# CITY OF ALBUQUERQUE

**Re:    Mountain Mahogany Community School PH II, 5014 4<sup>th</sup> St NW,  
Request for Permanent C.O. –Accepted  
Engineer's Stamp dated: 03-01-12, (F14/D062)  
Certification dated: 07-12-12**

**Re: Mountain Mahogany Community School, 5014 4<sup>th</sup> Street NW**  
**Grading and Drainage Plan**  
**Engineer's Stamp date 3-01-12 (F14/D062)**

**Re: Mountain Mahogany Community School, 5014 4<sup>th</sup> Street NW, Grading and Drainage Plan**

Date:	No.	Revisions	Date:	Job No.
01.13.12				1903
Drawn By:	-			CG-101
BJB	┵			00 101
Ckd By: FCA				SH. OF
FCA				Jul. G

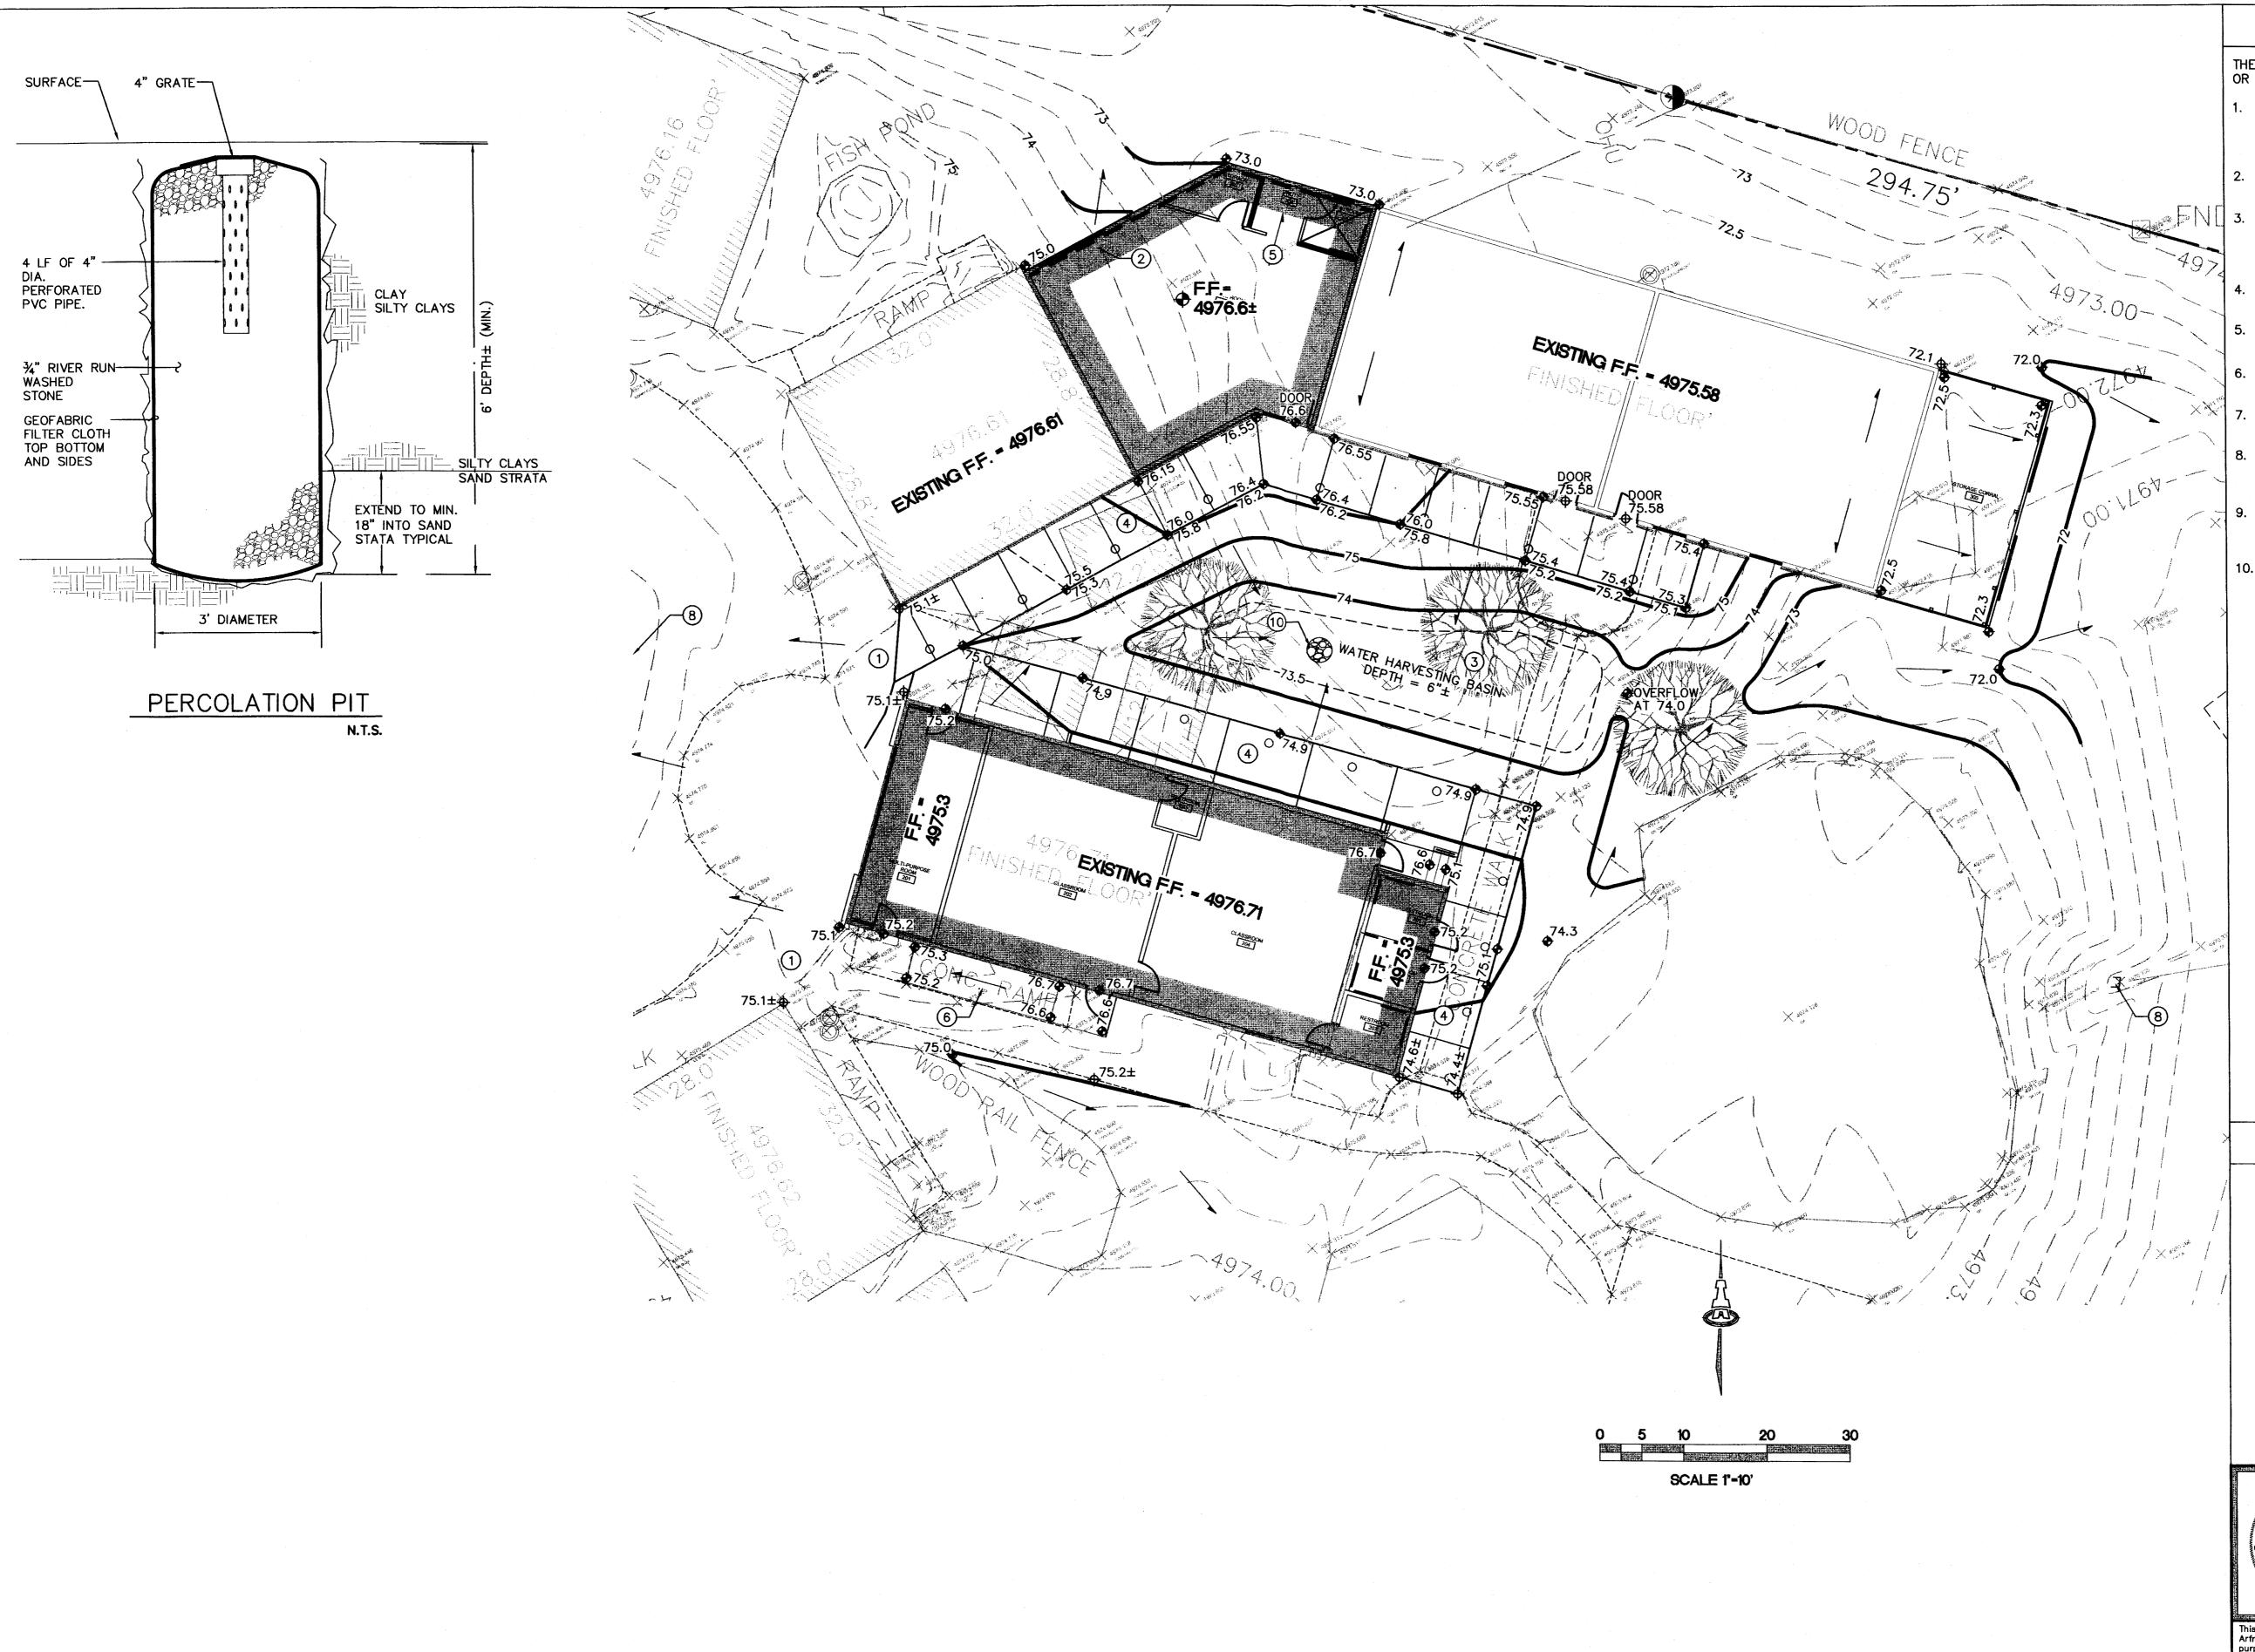
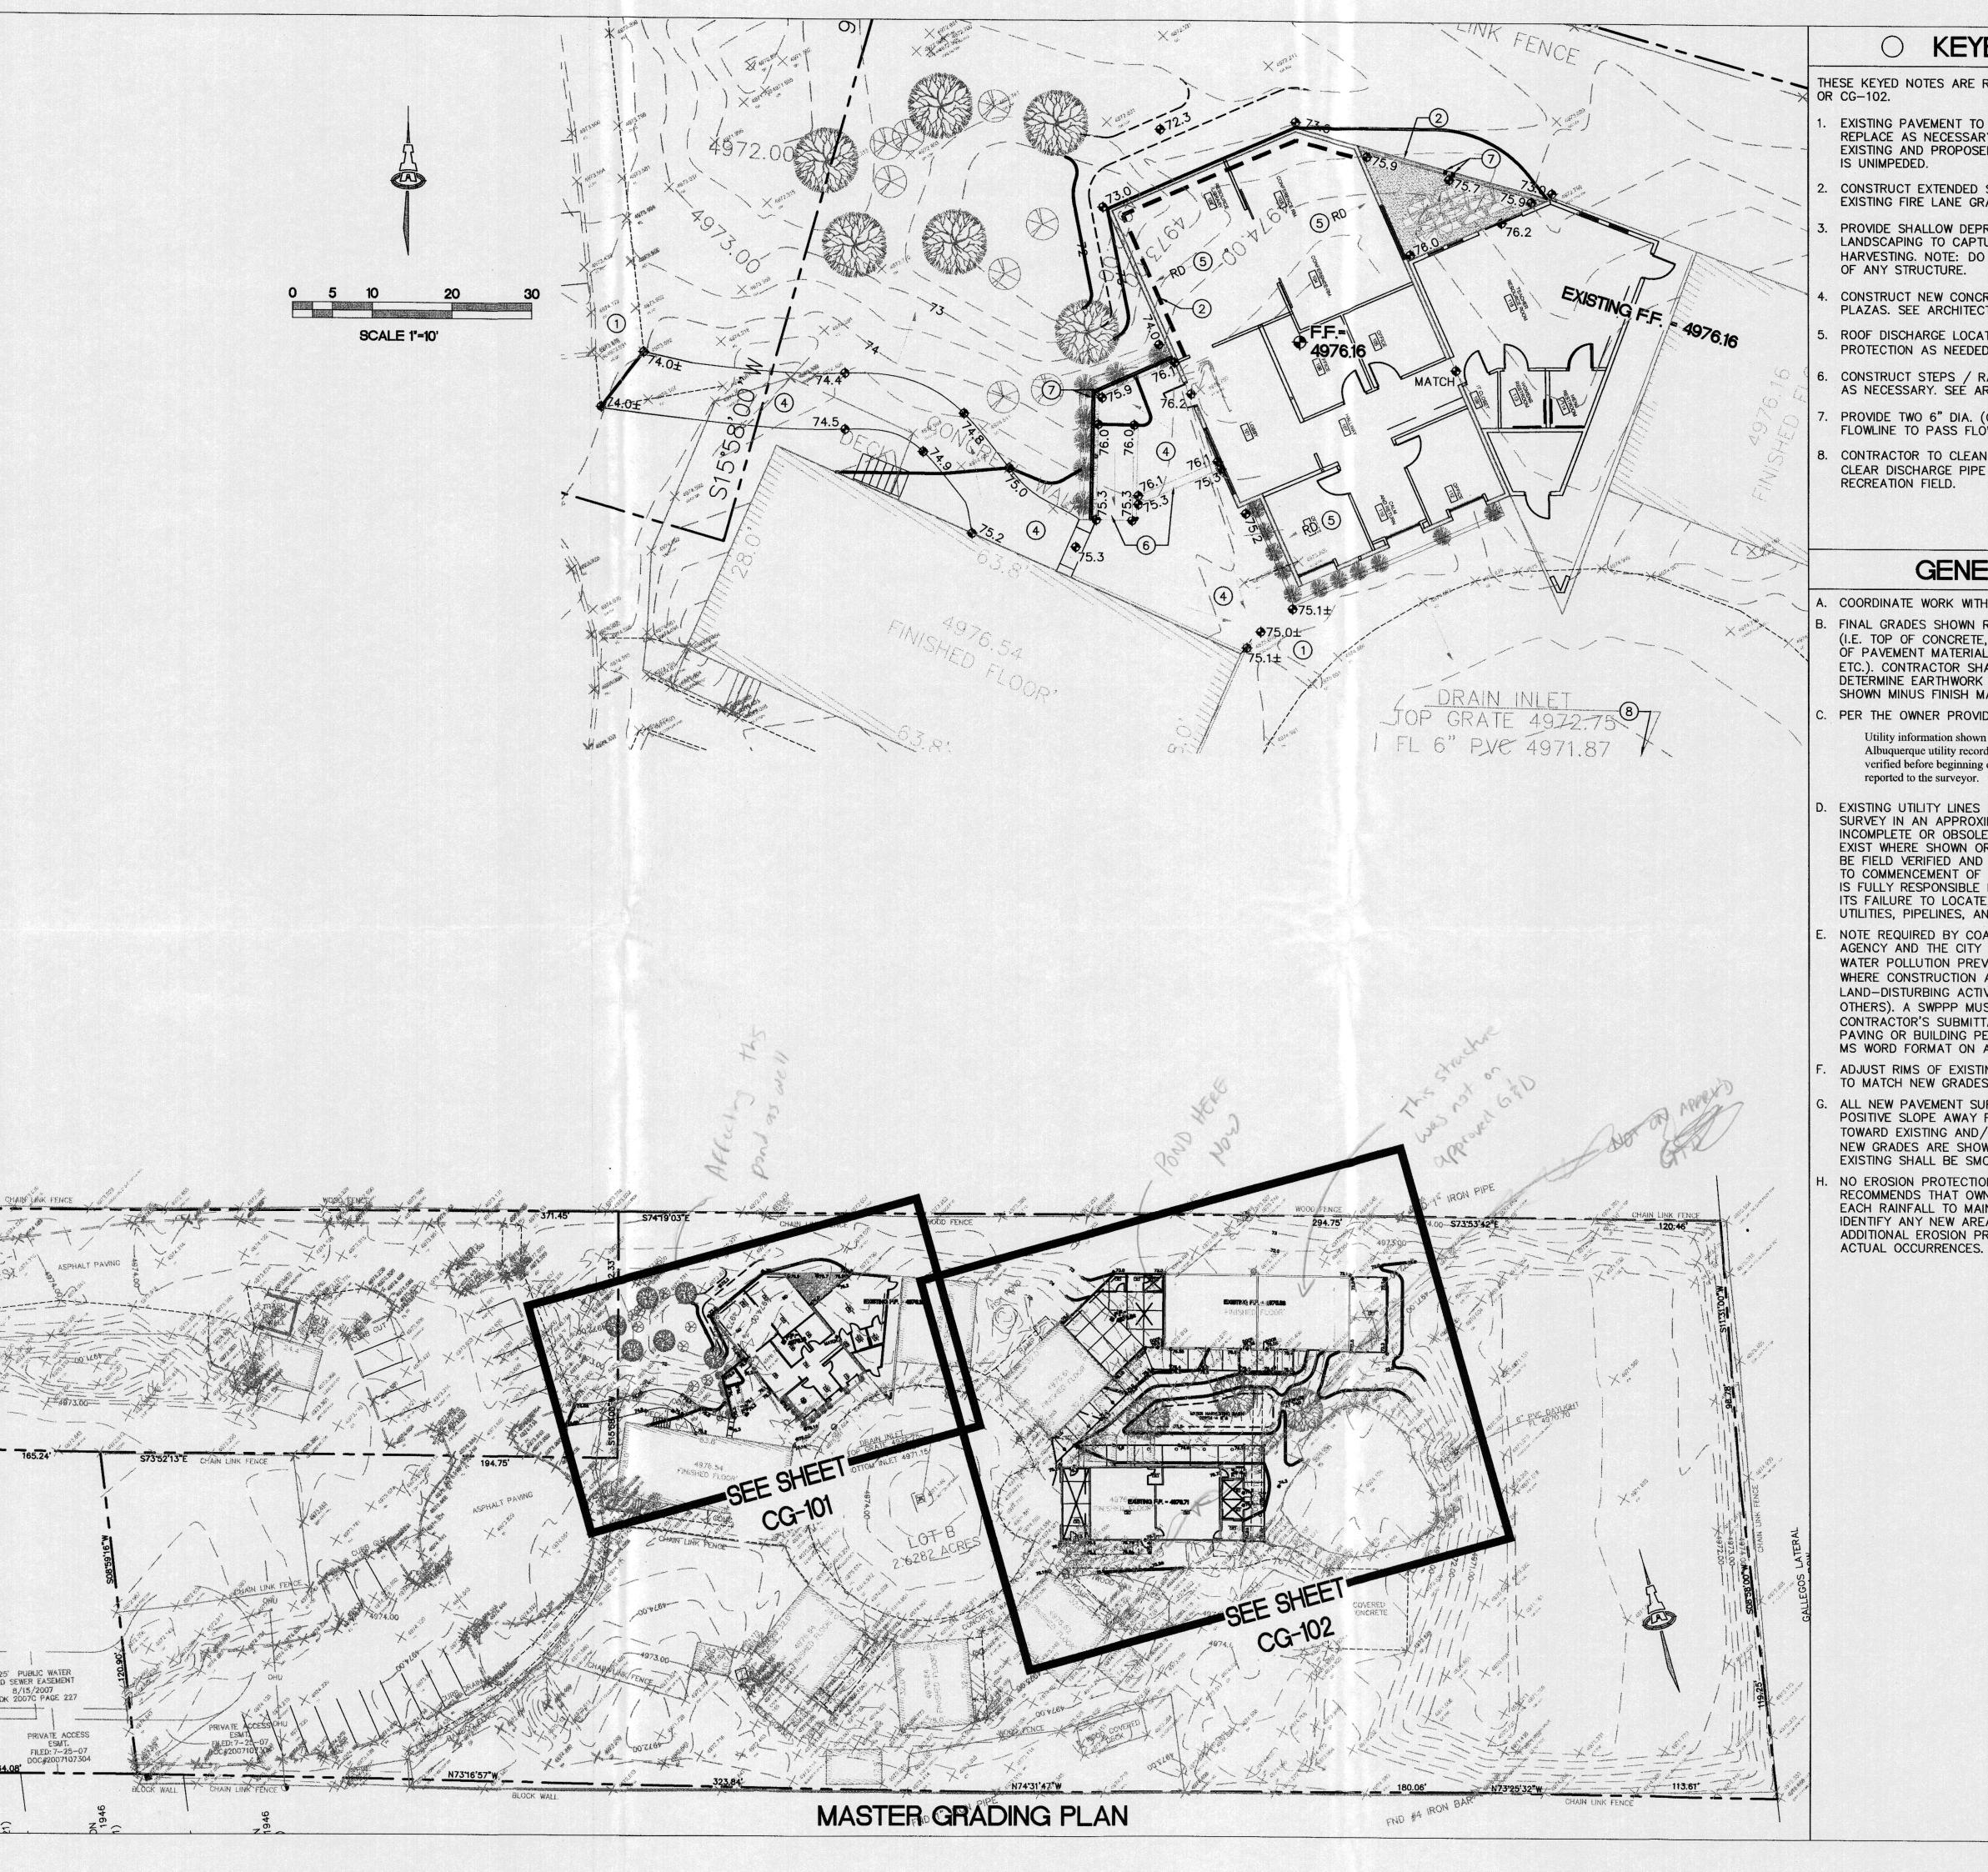
- An approved Grading and Drainage plan is on file for this property and the proposed grading appears to impact the on-site retention ponds that were approved to contain the 100 yr, 10 day storm event.
- One of the existing structures was previously built without a permit and encroaches on one of the approved retention ponds.
- The proposed structures also appear to encroach on another on-site retention pond.
- Provide pond volume calculations to ensure proper water retention is maintained.

Mr. Biazar, In response to your review comments dated January 27, 2012, I have made the following revisions to the plan:

1. A pond volume analysis is included in the supplemental information to address the proposed construction as well as to provide for some additional future improvements.
2. We have called for the installation of six percolation pits within the various ponds to assist with draining the ponds. There is a shallow clay lens (within the upper 4 feet).
